LSC Responses to El Paso County Department of Public Works Comments

Gateway Trucking

PCD File No. PPR-21-033

Review #1 comments received from Department of Public Works (DPW) on Nov 4 regarding the Gateway Trucking Transportation Memorandum (dated May 20, 2021):

Figures 1-9

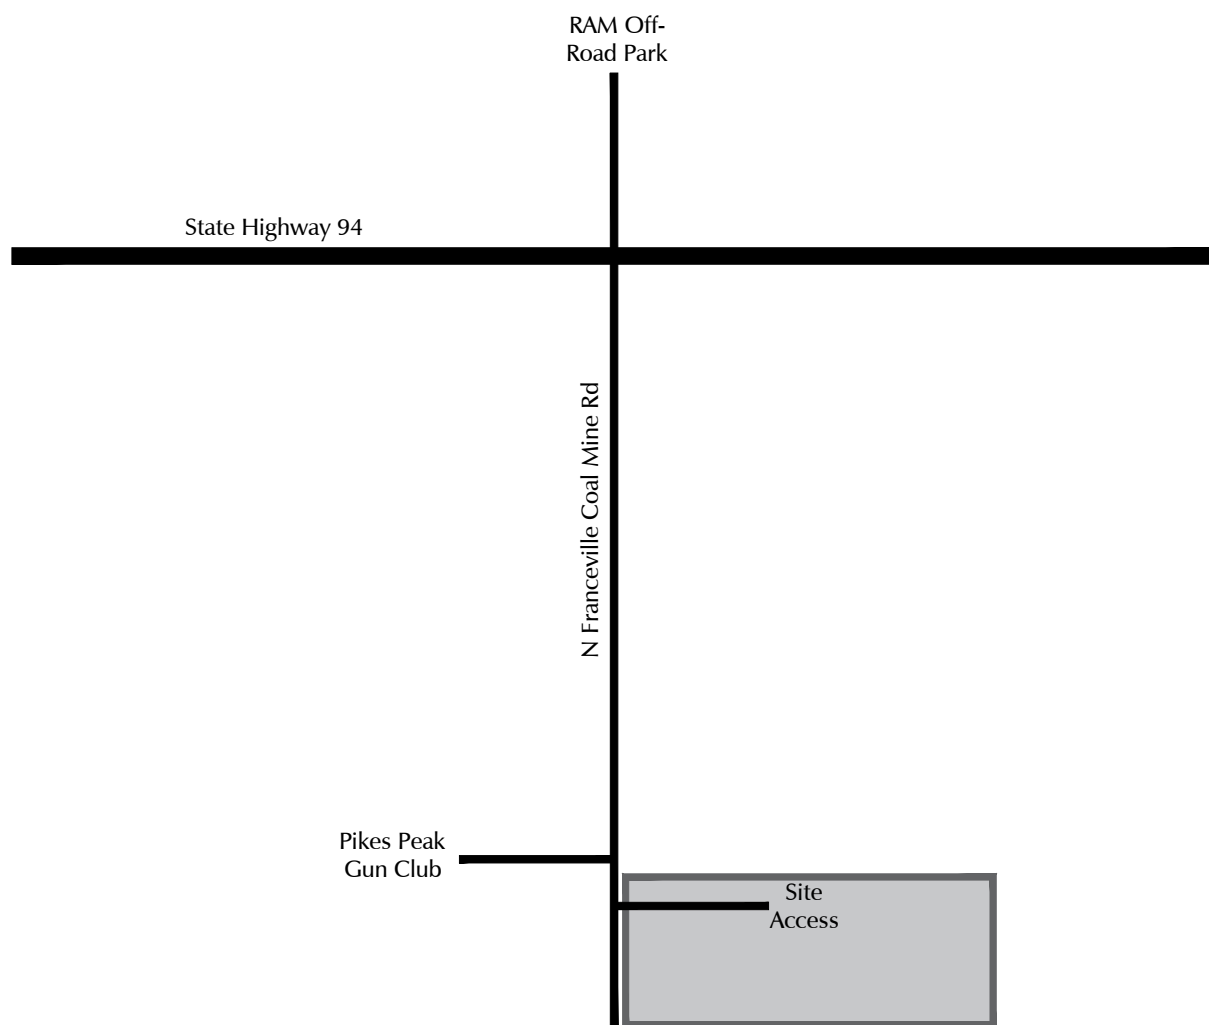
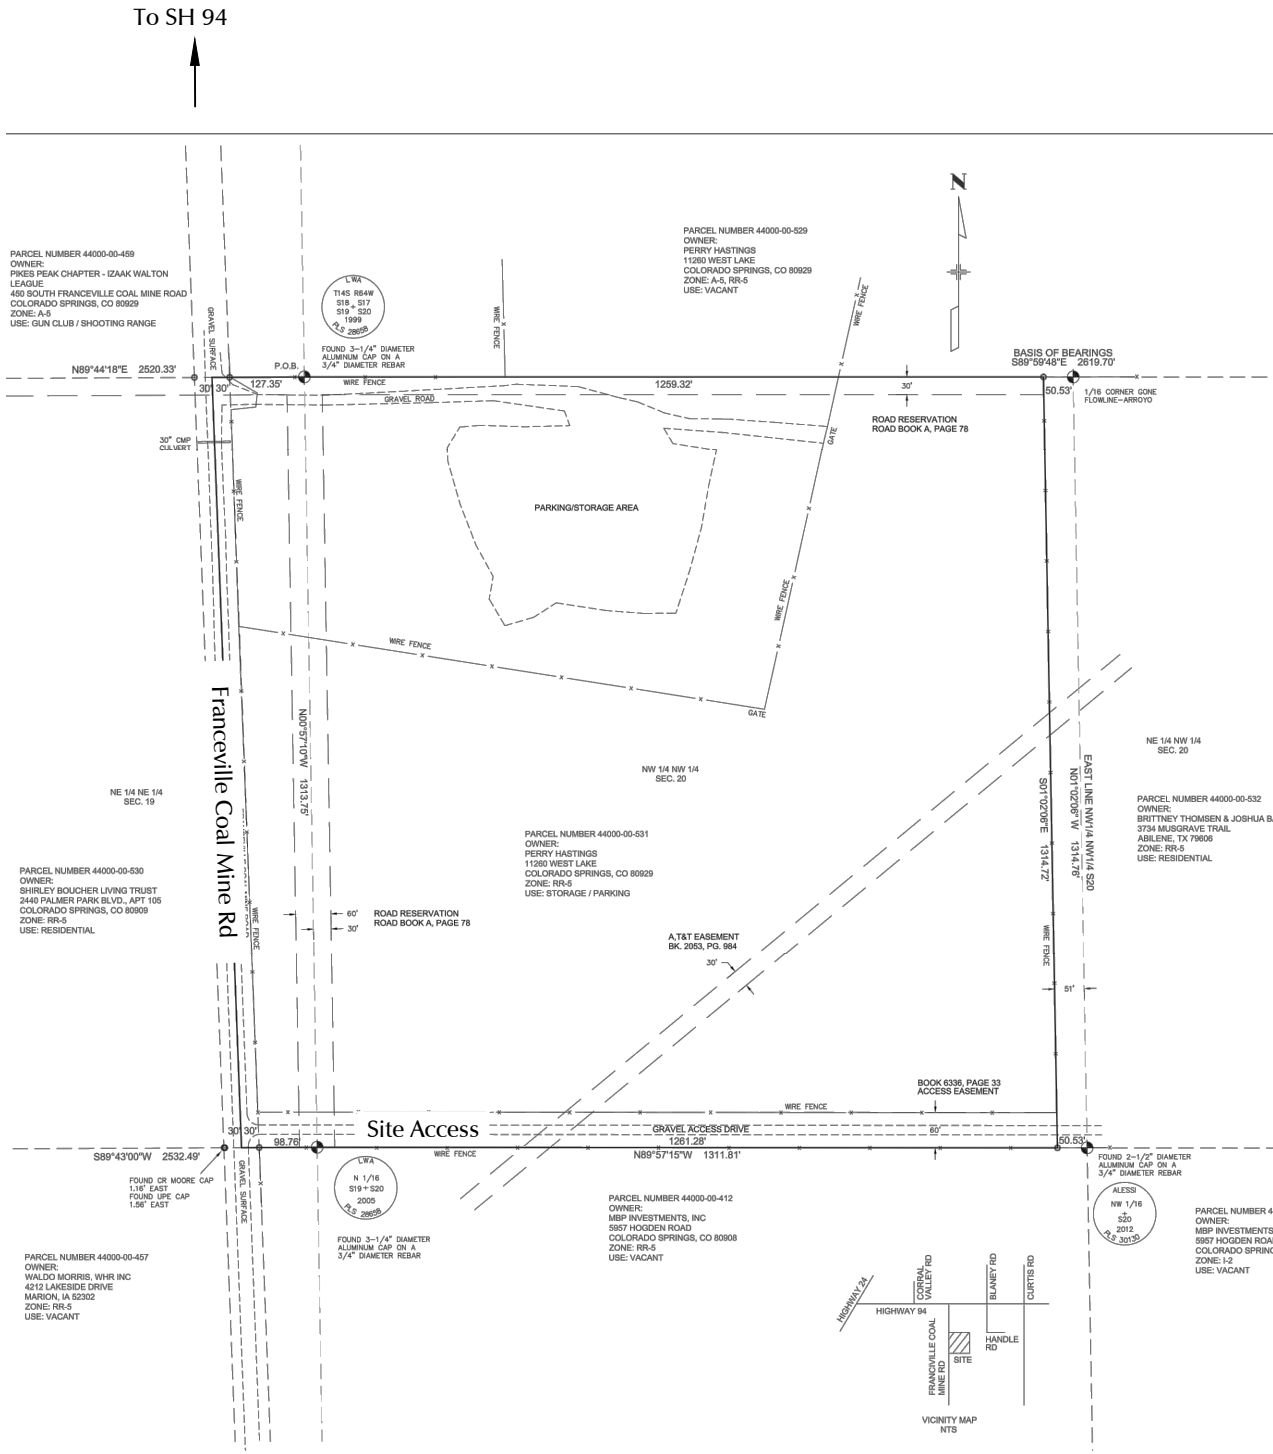
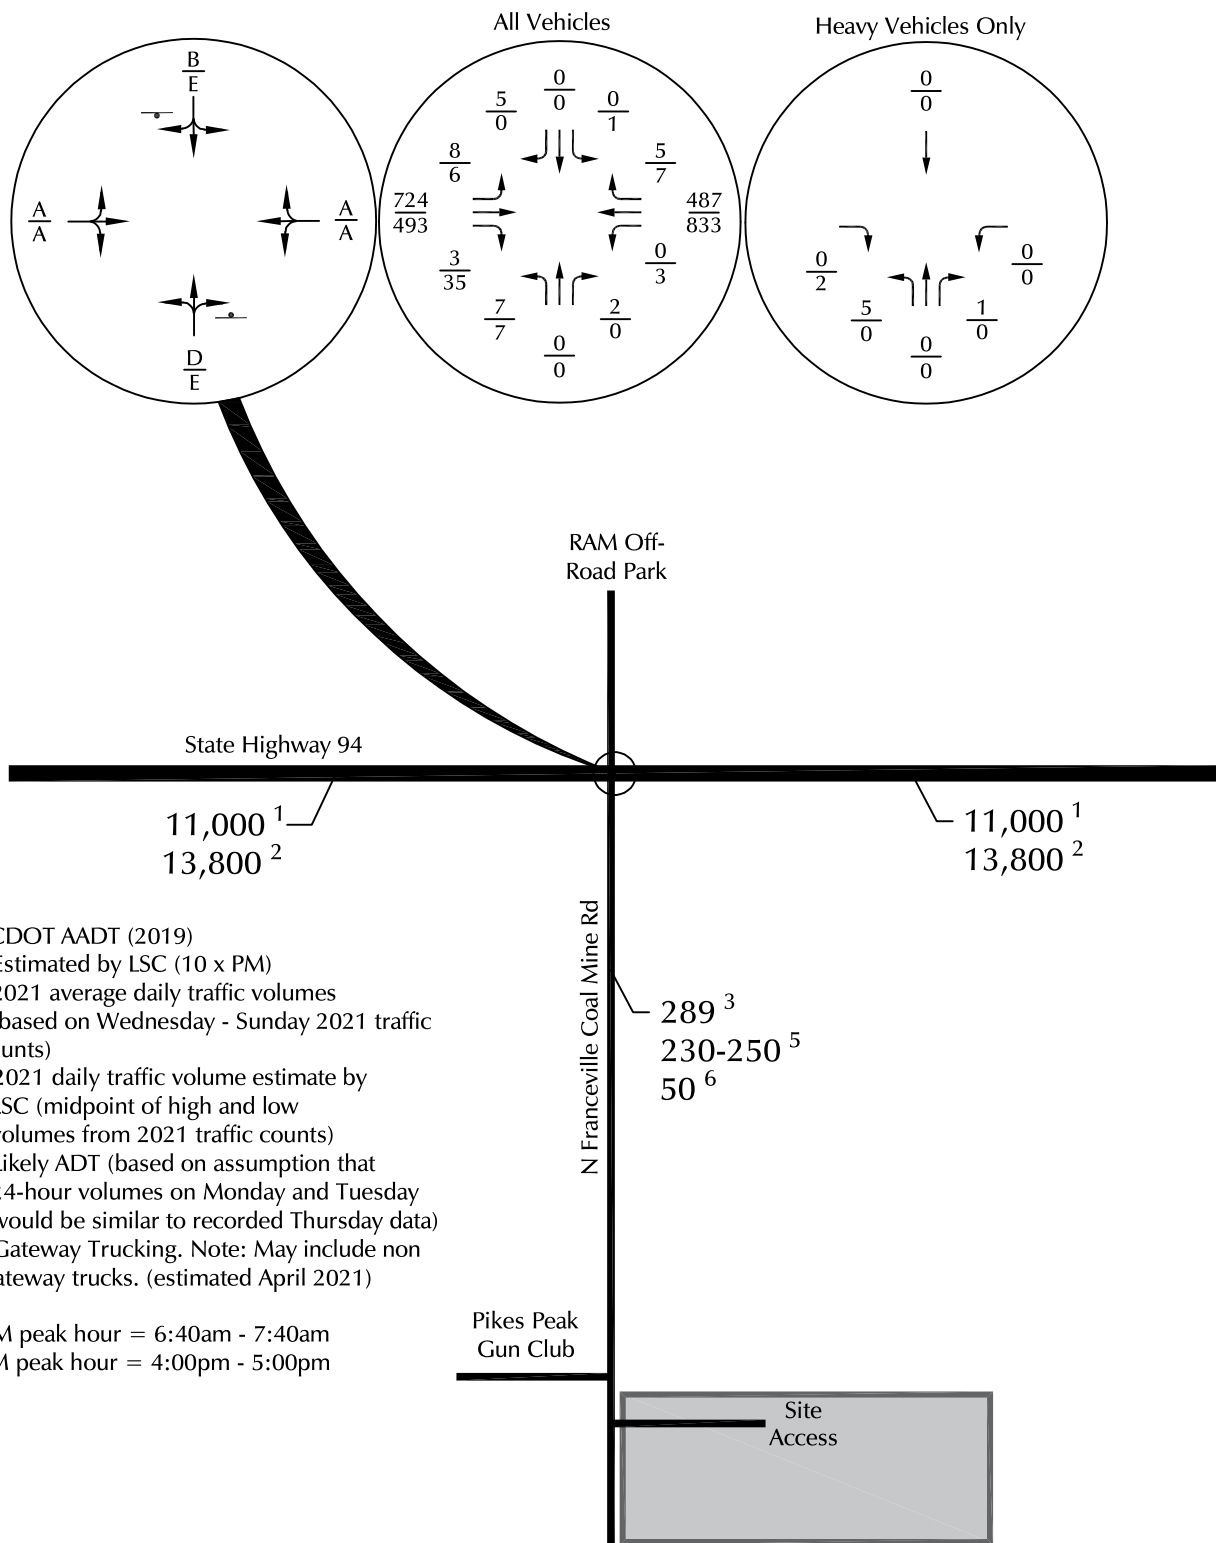
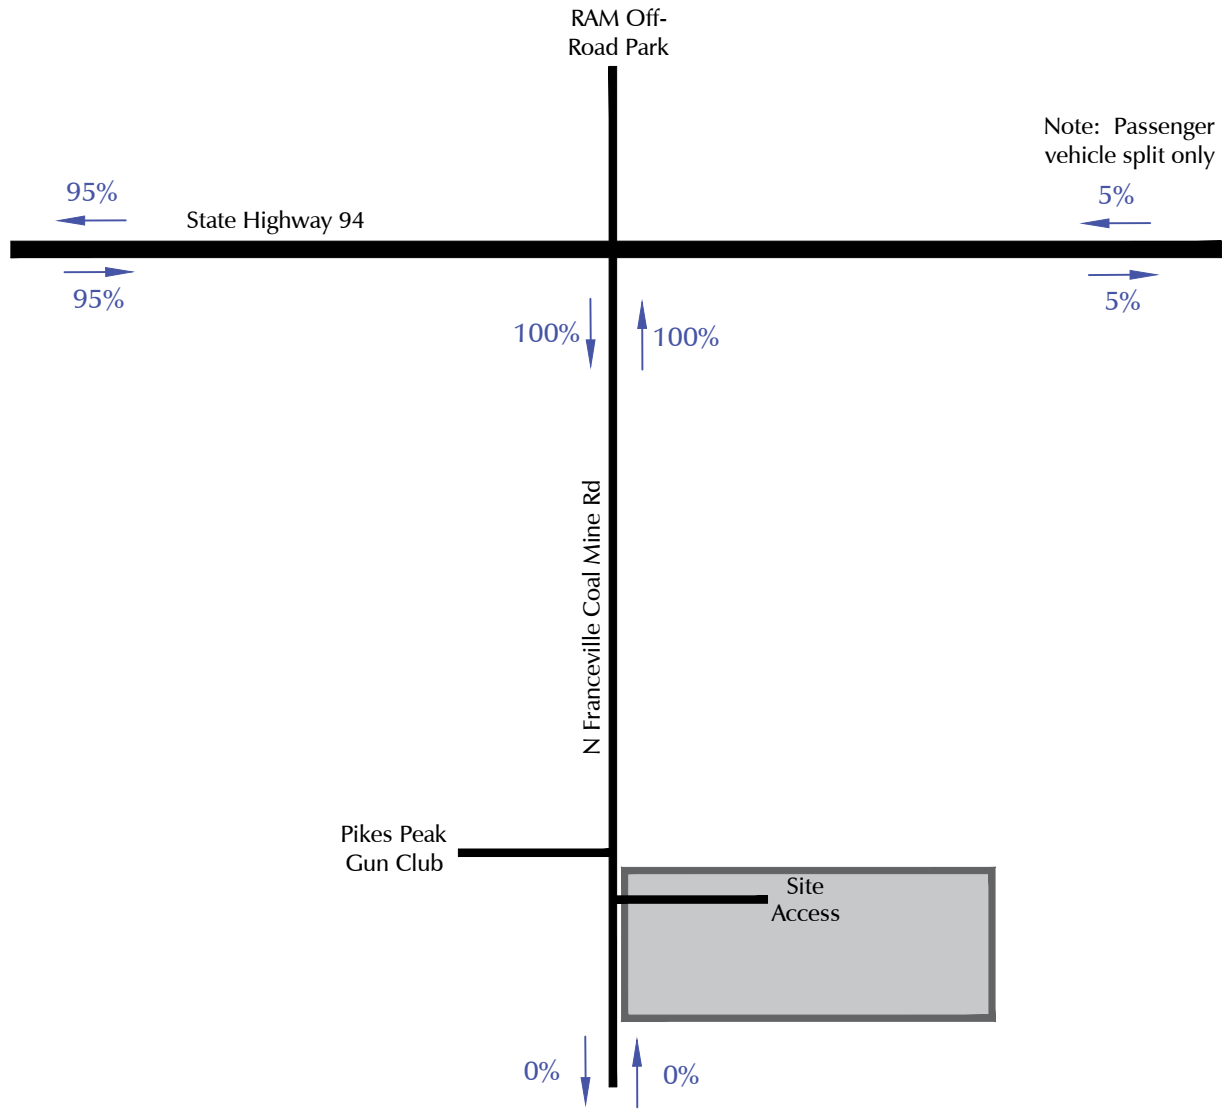
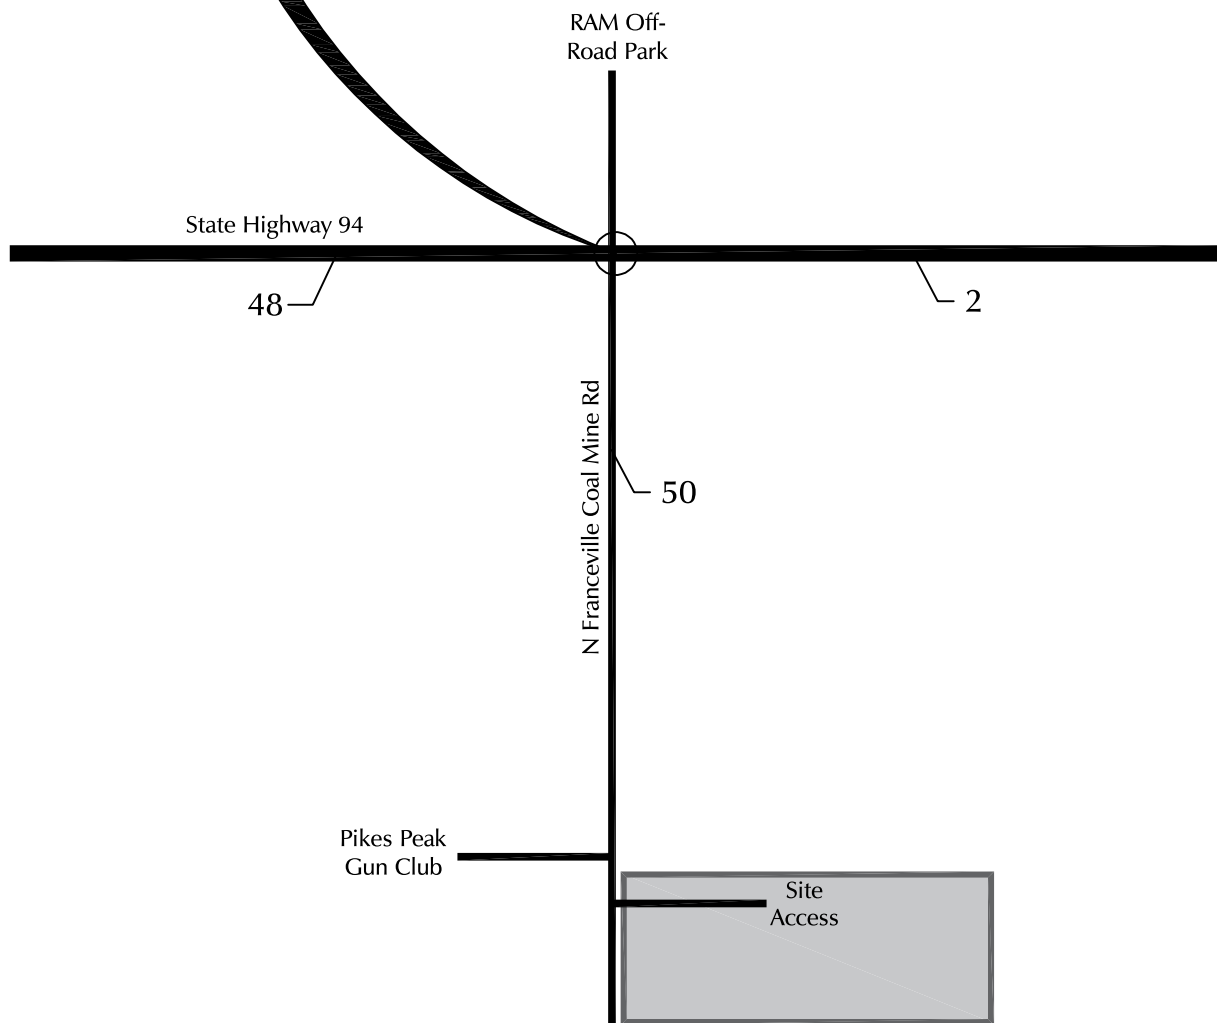
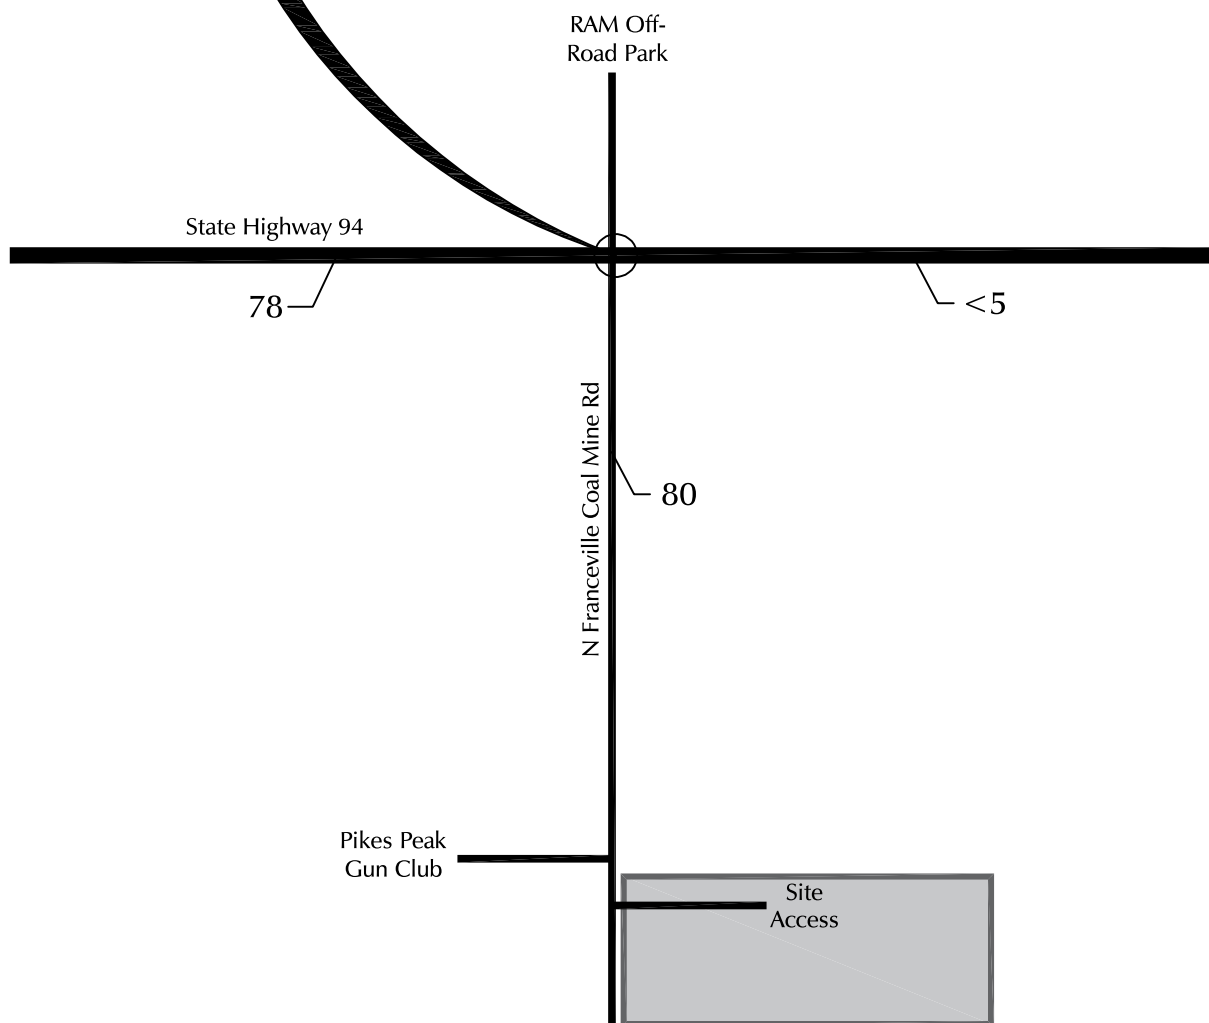
(2) – Pg 12, 2nd paragraph states “LSC estimates that during peak season, when all 20 trucks are used for local projects, the site generates about 80 vehicle trips on the average weekday, with about half entering and half exiting the site during a 24-hr period.” Upon some cursory investigation via google maps satellite view, it appears the level of trucks/vehicles operating exceeds these estimates. Recommend developer and consultant provide and submit explanation on the attached satellite views.

LSC Response: It is our understanding that the average trip estimates originally provided by the applicant remain accurate/valid. Regarding the aerial photo imagery, some of these additional vehicles are the owner’s personal equipment located on his adjoining property. Please refer to the updated Letter of Intent for additional information.
